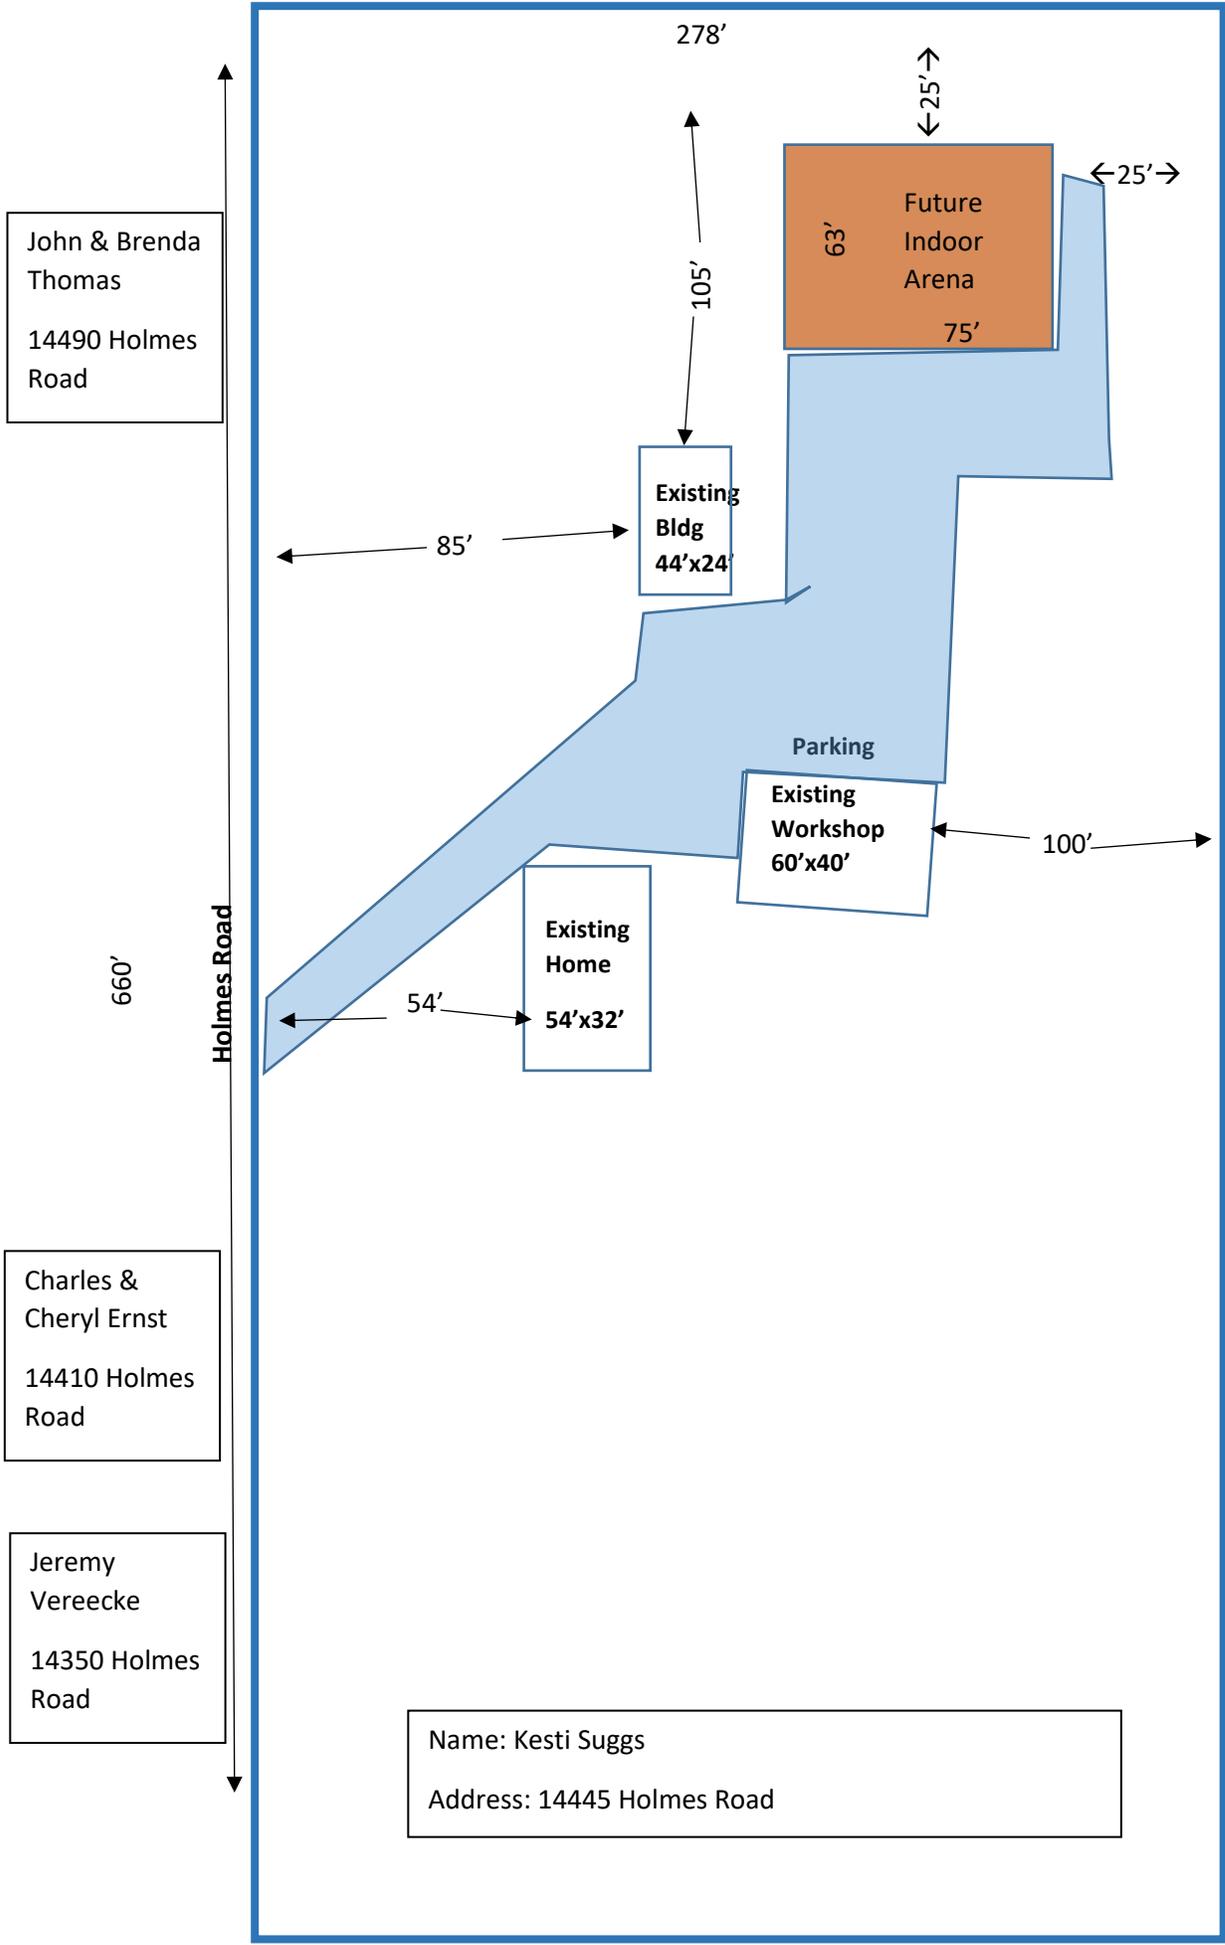
~~304'~~ 278'

~~188'~~

Please remove all numbers with just a slash through them, we only need the distance to the closest property line. Please also make the changes noted.

~~130'~~
